Planning Application No: 3/2021/0275 The Dog Inn Market Place Longridge PR3 3RR

I am writing to let you know of my objections to the proposal.

JOB NO 3156
DRAWING NO 120
REVISION E
SCALE 1 : 200 @ A1

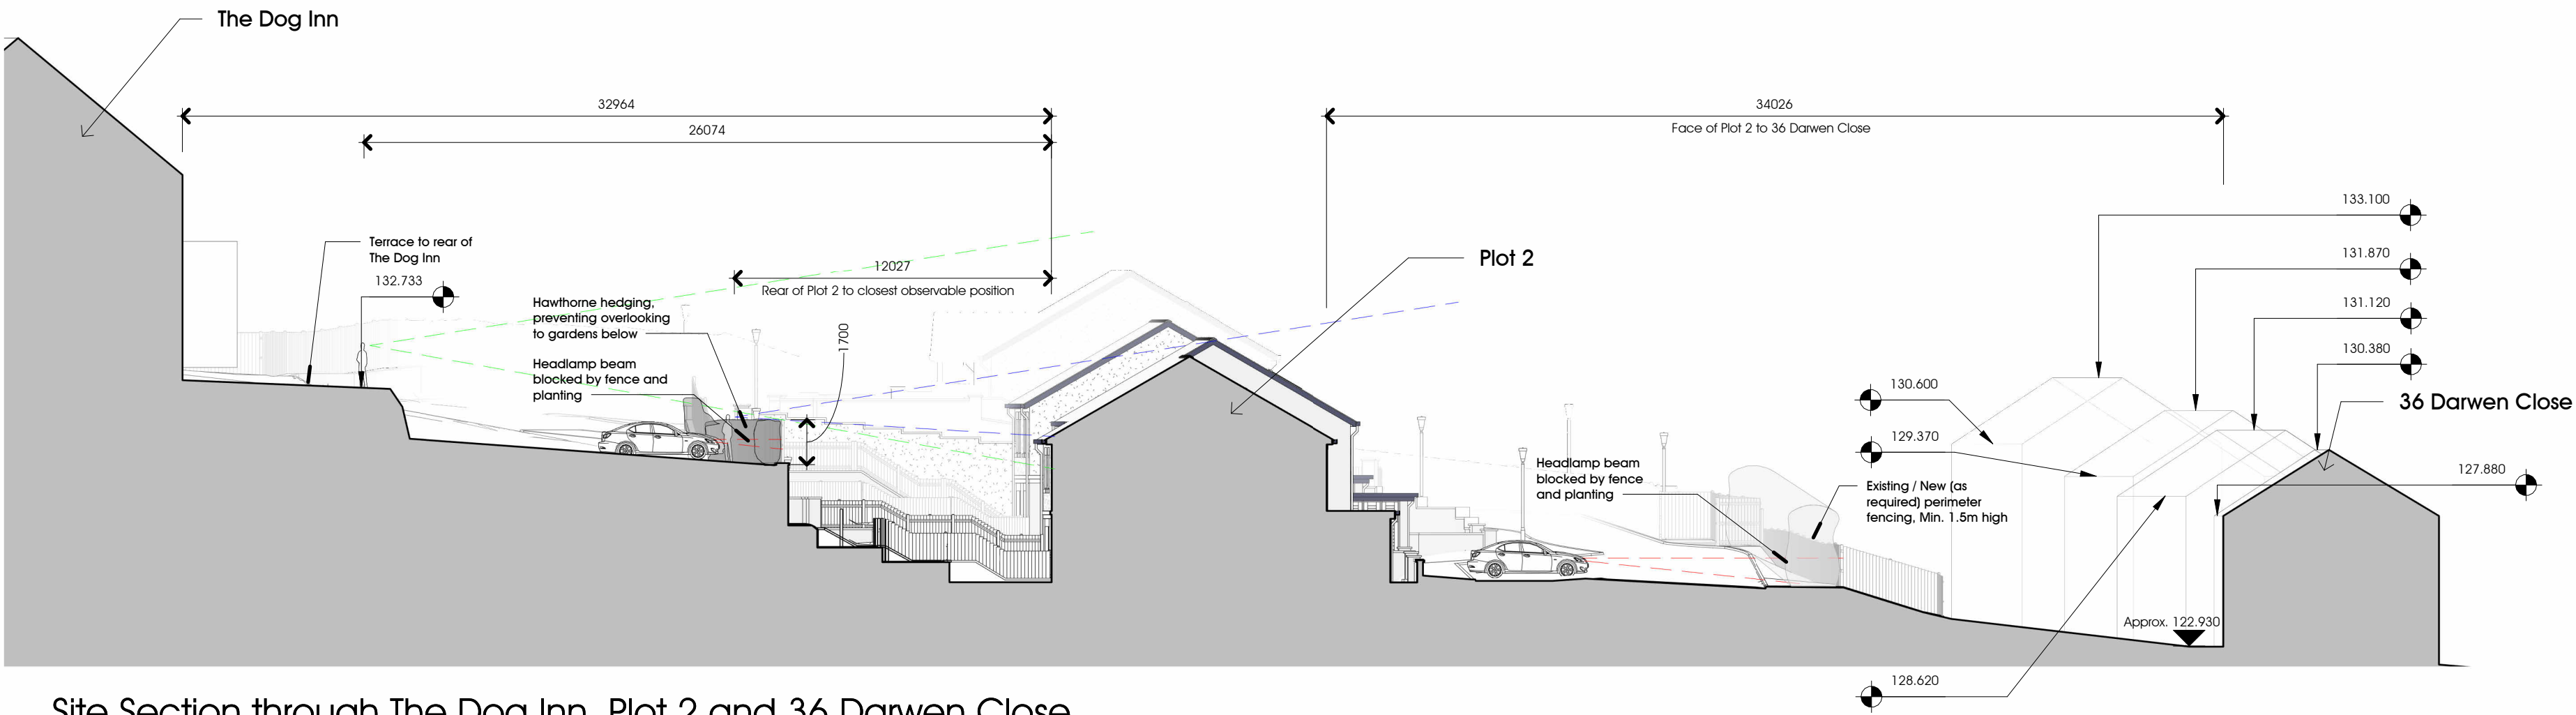
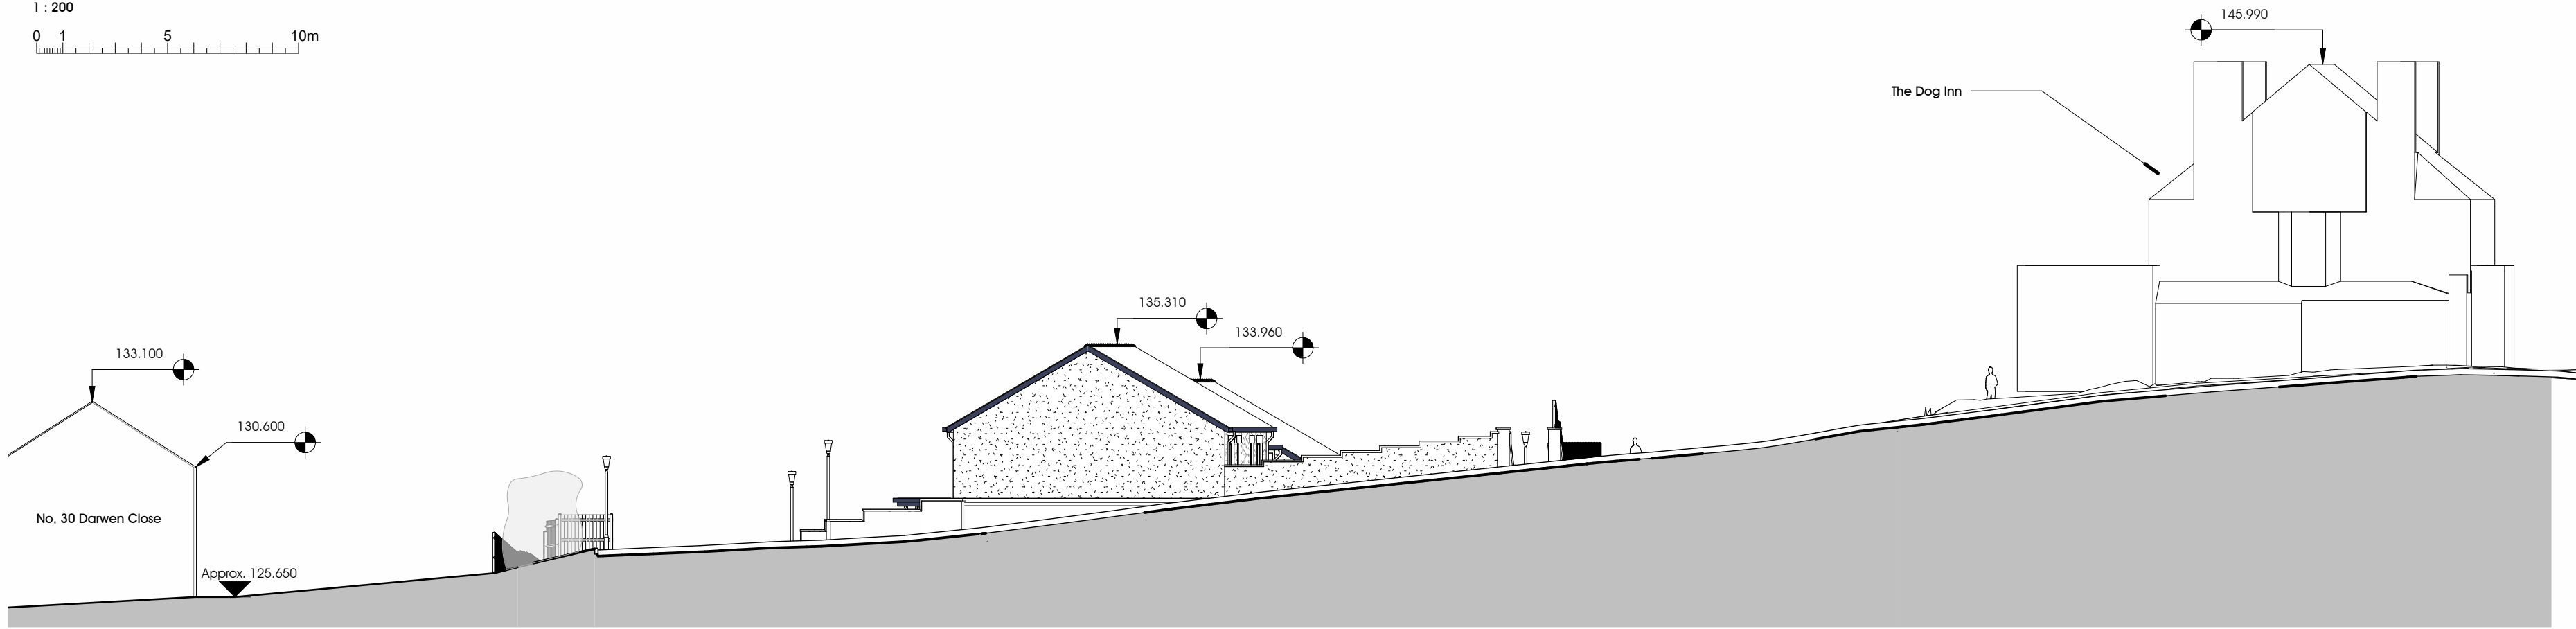
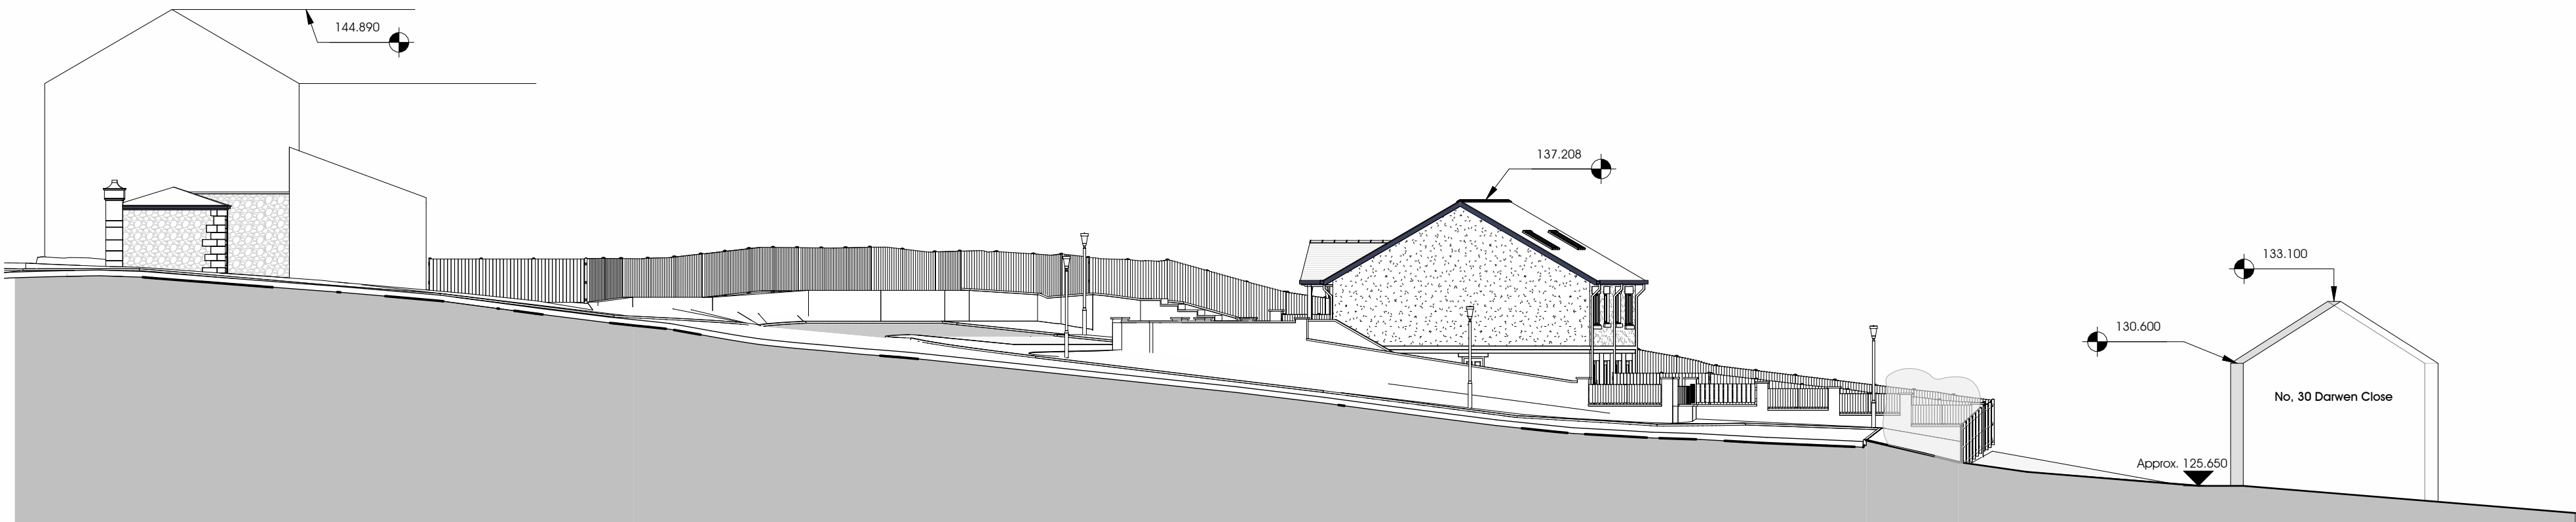
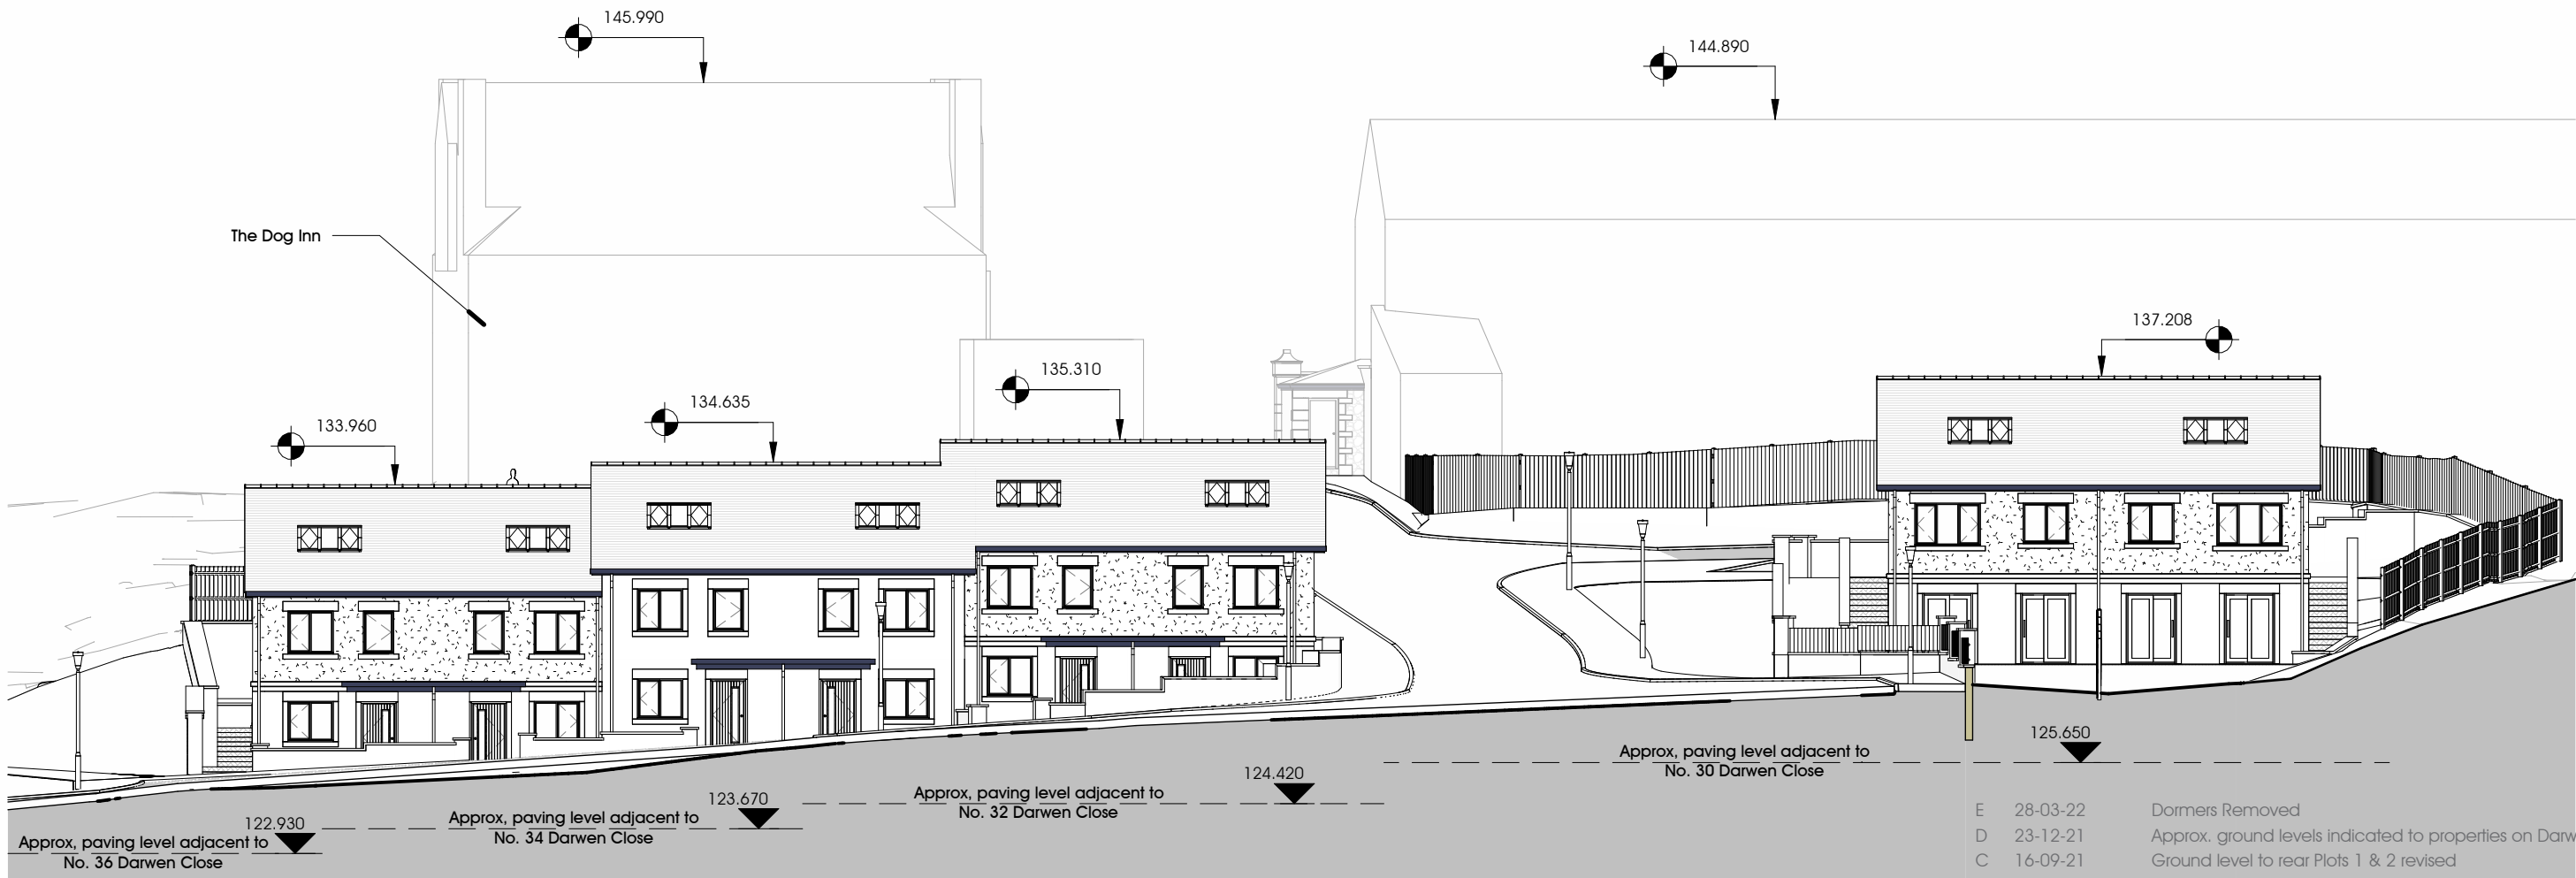
1. Due to the close proximity and height, of the two premises at the east of the site, to [REDACTED] properties, there will be loss of sunlight putting [REDACTED] all into shade all day.

Proposed Site Plan
1 : 200
0 1 5 10m

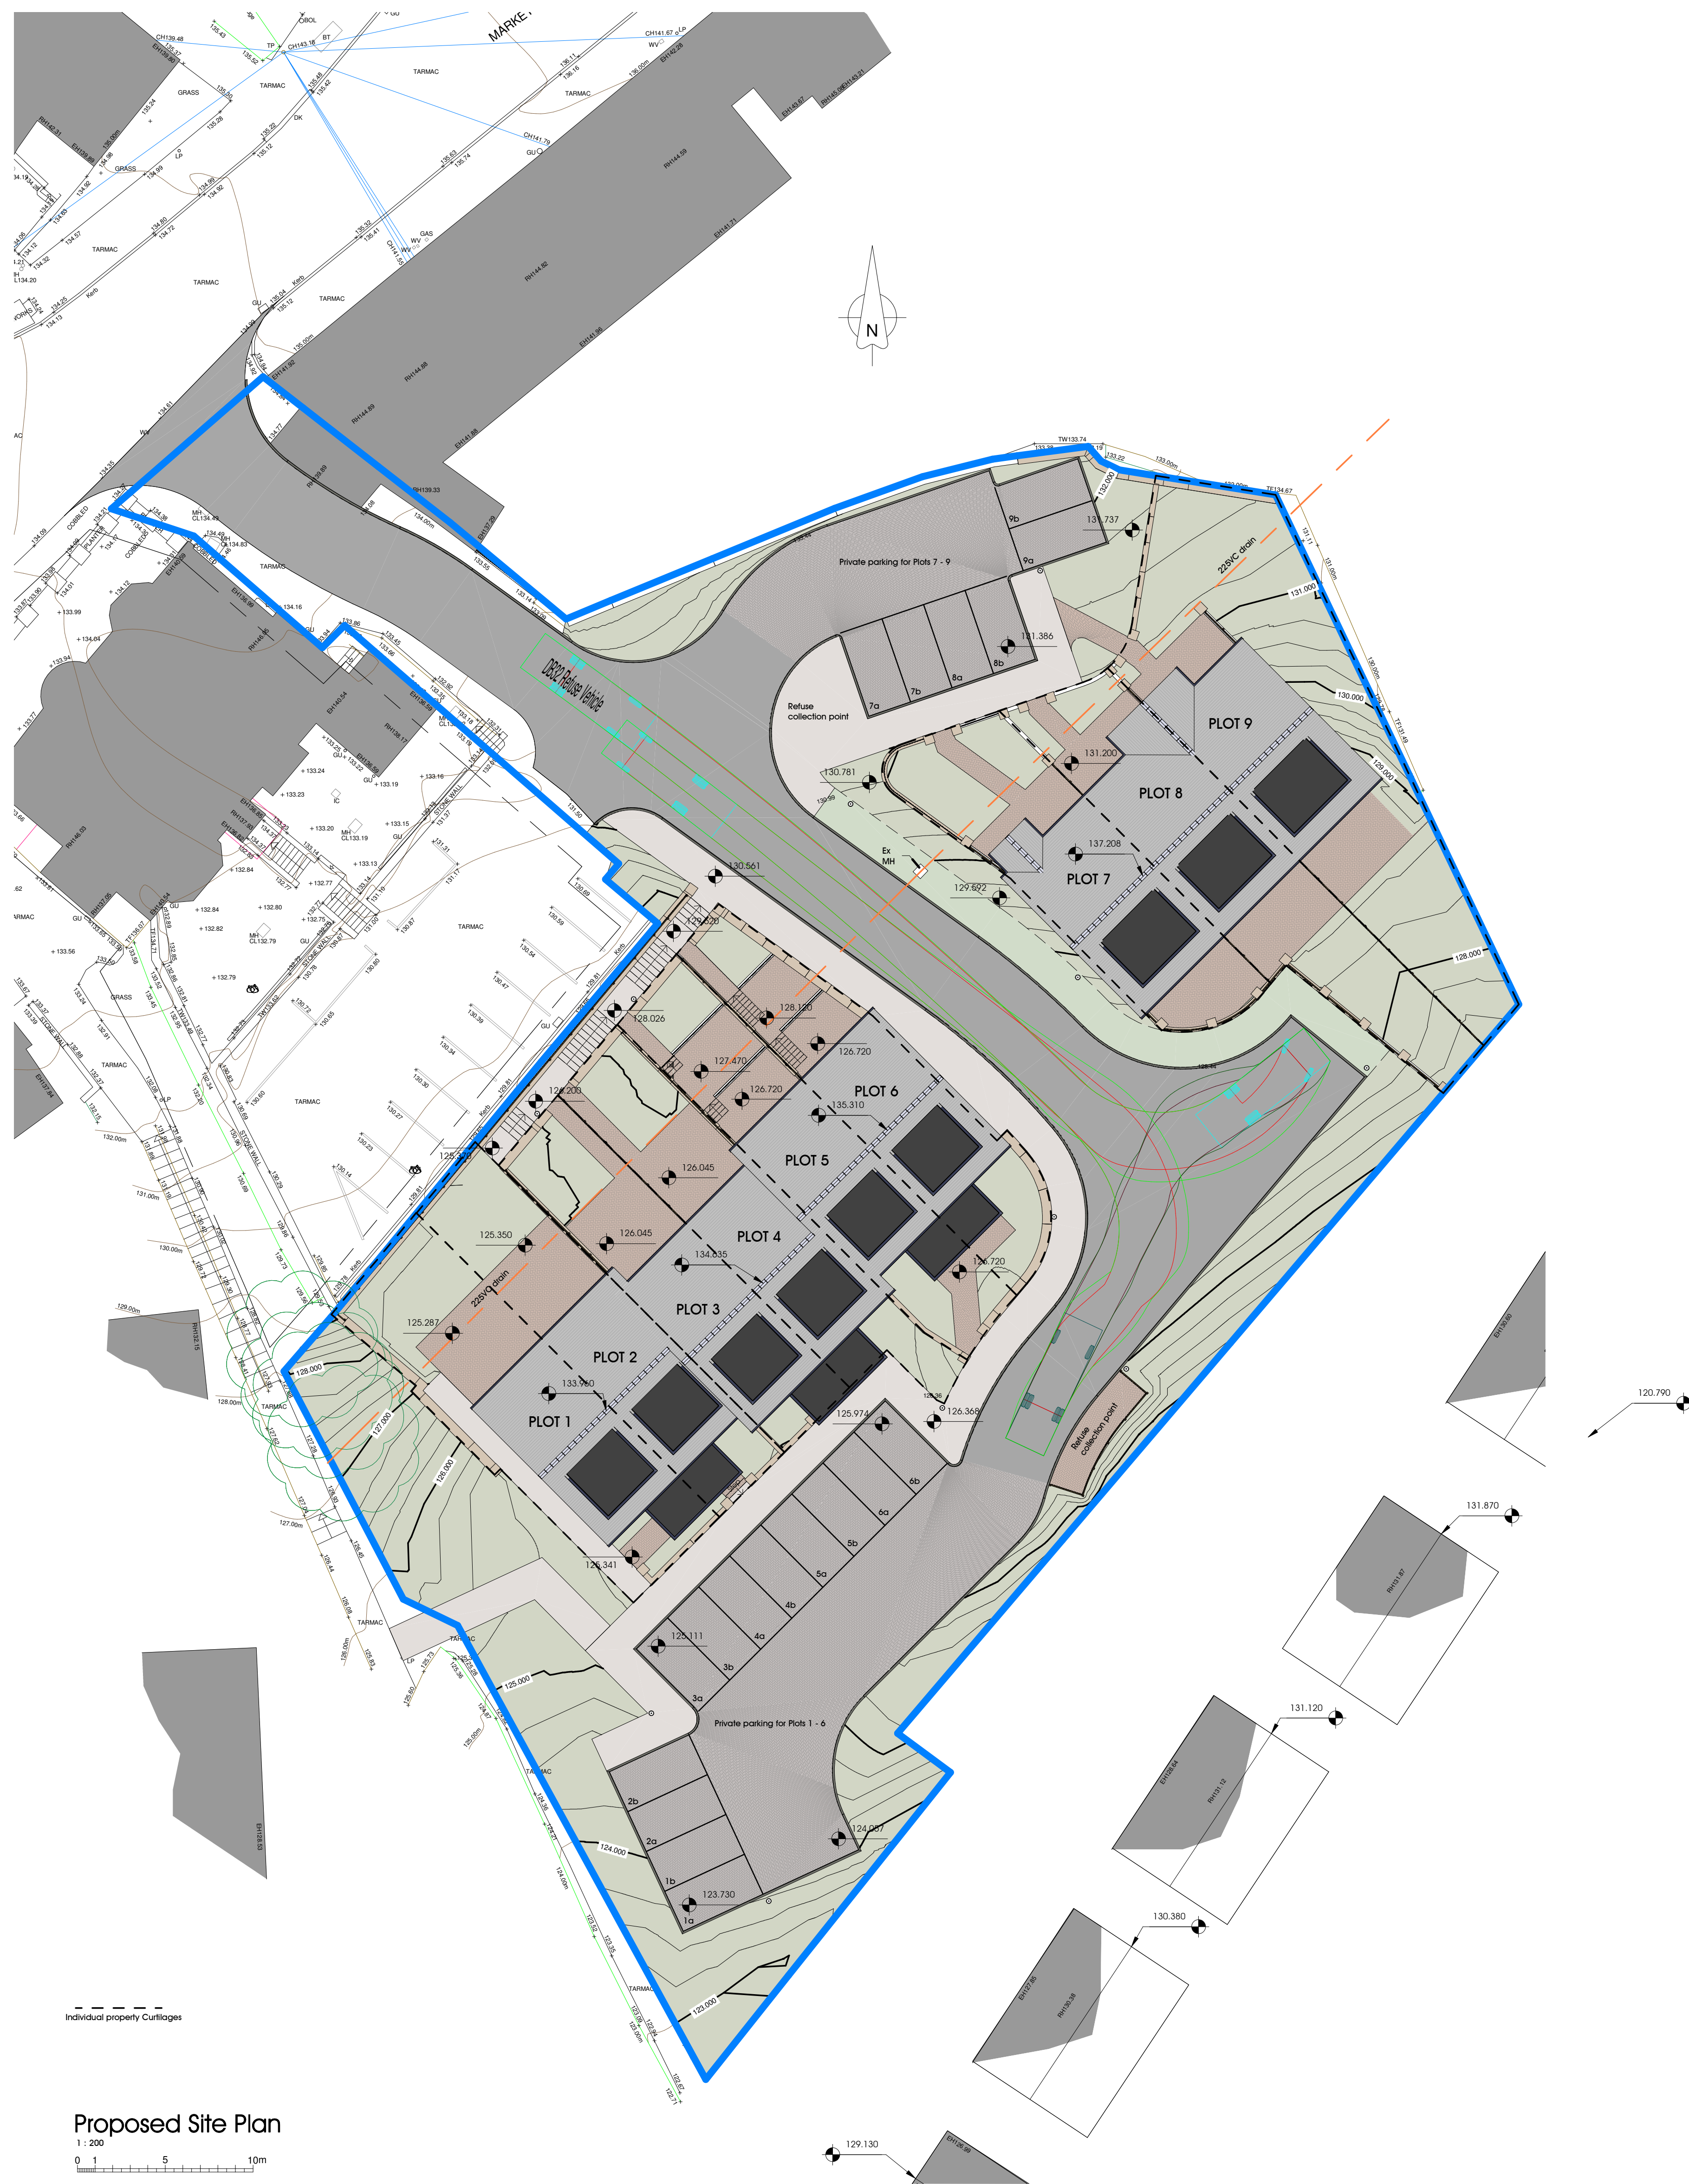
2. I believe the ideal number of properties behind The Dog Inn is 4 with adequate spacing for boundaries and adequate provision for drainage.
3. I strongly believe that the council needs to put in place strict guidelines for the builders conduct such as times and days starting and finishing eg no weekend or bank holiday working or early mornings and late evenings. Our existing experience of [REDACTED] makes this essential. Groundworks have already taken place prior to planning permission, such as large quantities of earth moving and bringing in hardcore to build the base for the road proposed in the planning permission. I would like to know what the penalties are for builders who do not follow planning rules and request that these are enforced.
